Circle A Subdivision, MS-20-7 (Revised 21 July 2021)

Please accept the following comments from El Paso County Public Health (EPCPH) regarding the project referenced above:

FINAL PLAT
CIRCLE A SUBDIVISION FILING NO. 1
JOB NO. 70-072
DATE PREPARED: 07/15/2019
DATE REVISED: 01/27/2021
DATE REVISED: 05/12/2021
DATE REVISED: 06/02/2021

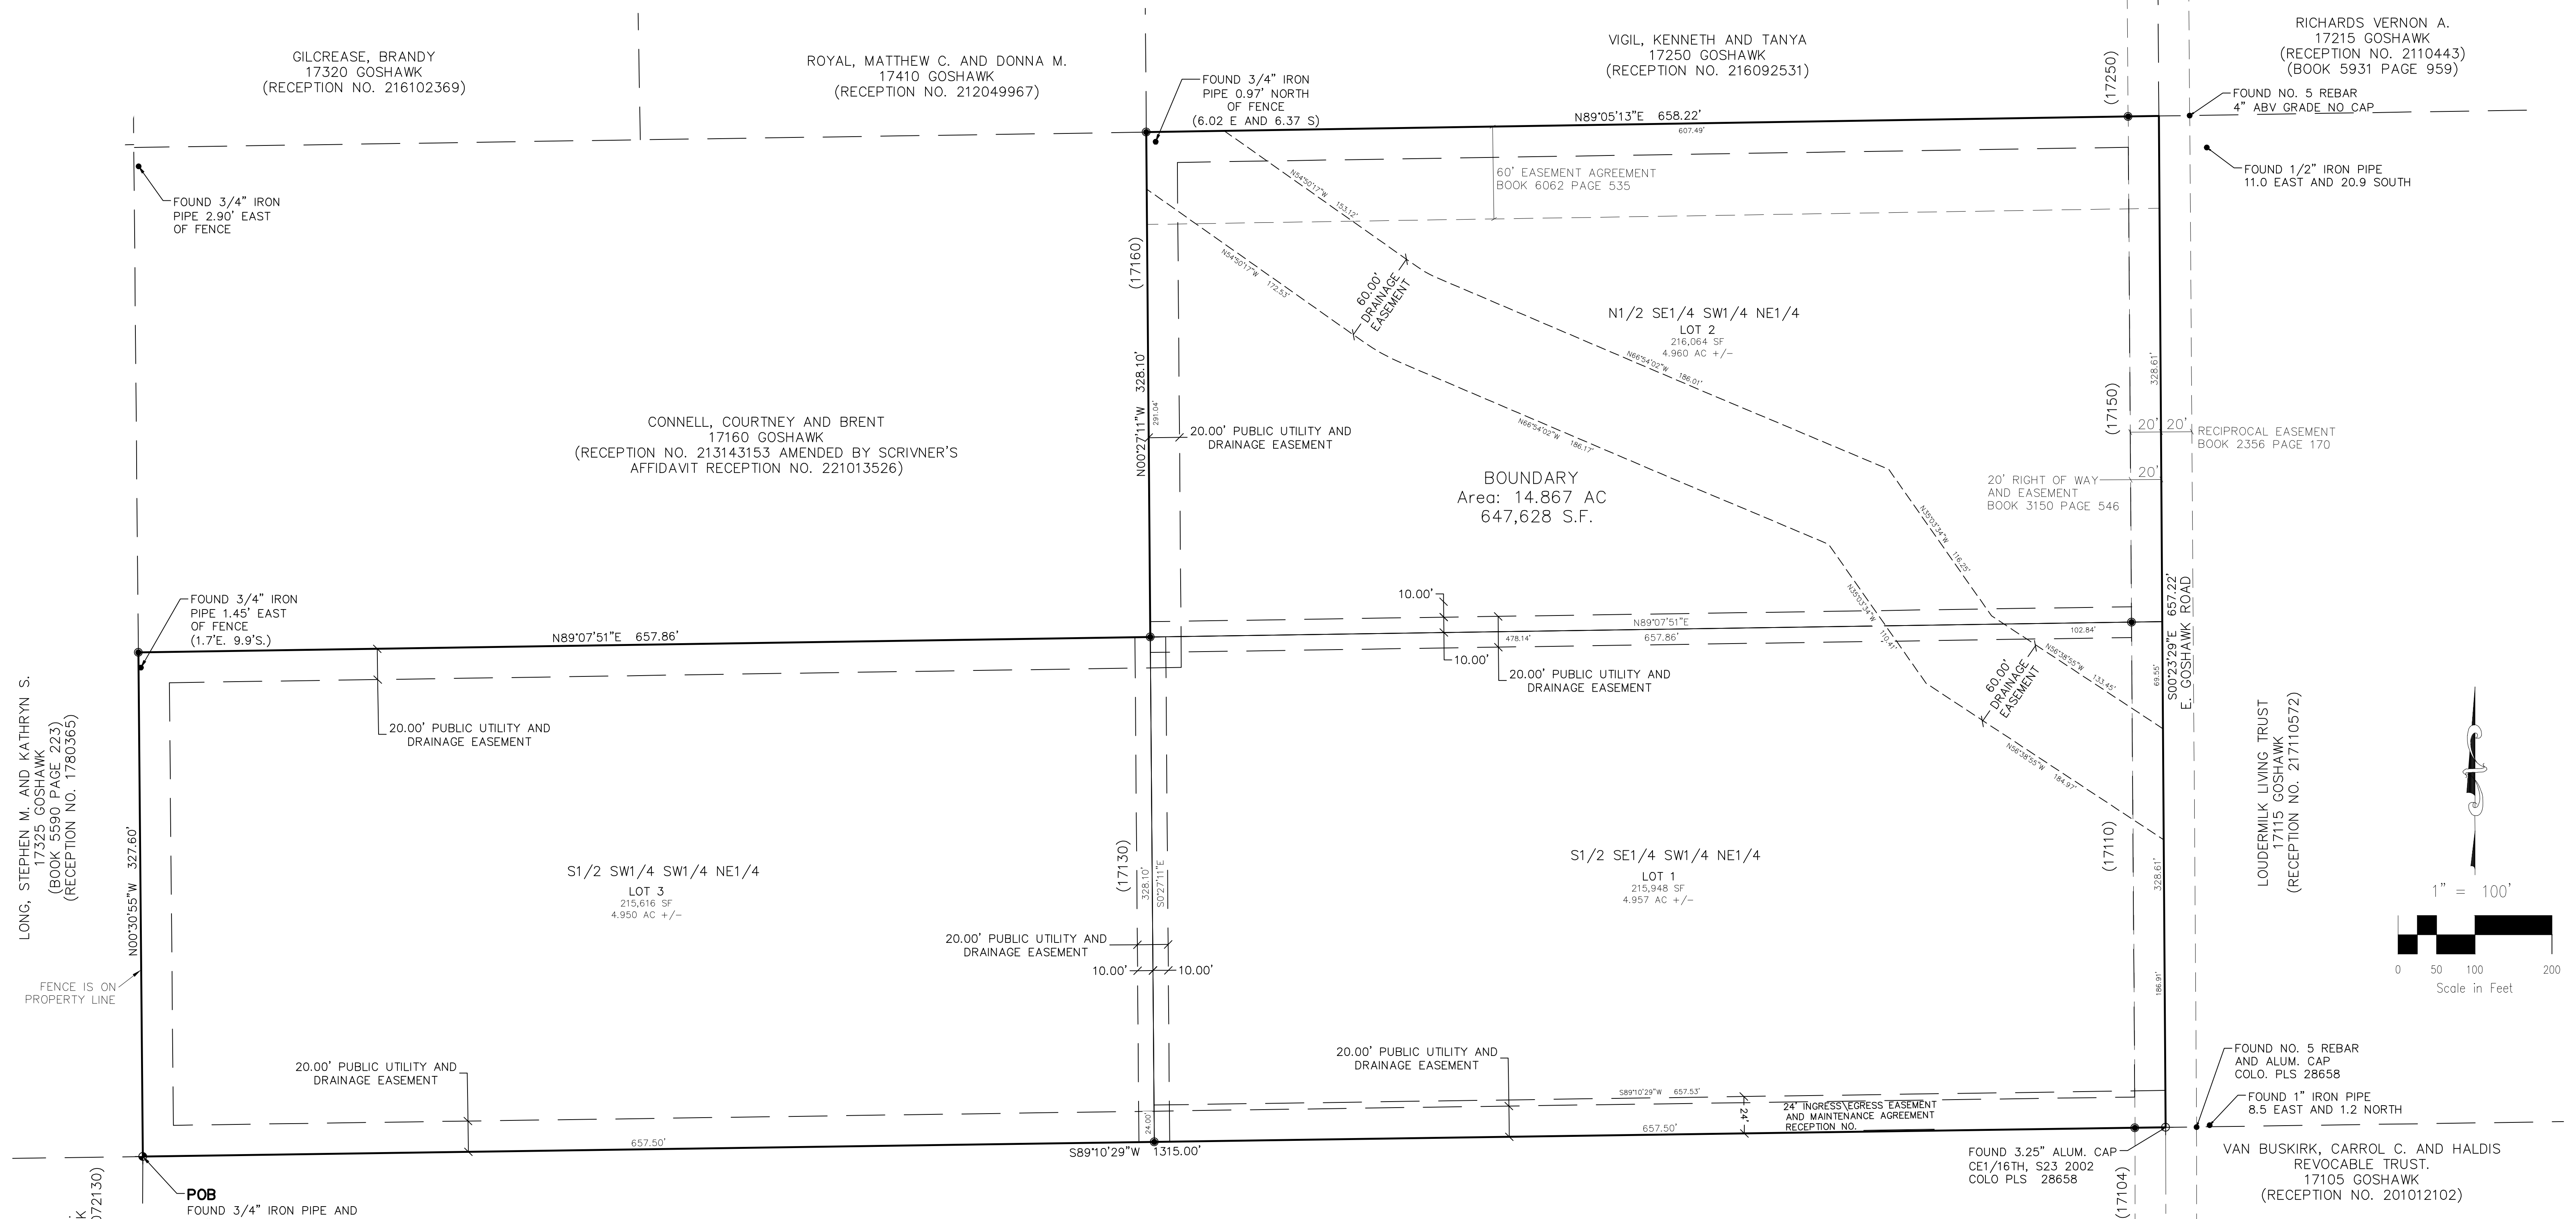
- **Adjacent property well locations were not shown; therefore, be aware of the specific 100'+ setback requirements to exterior wells.**
 - **The existing OWTS on Lot 1 was installed and approved in 1978; however, because the OWTS was installed prior to the modular being placed on the lot, the exact location of the OWTS in**

relationship to the house was not indicated on the EPCPH map drawing.
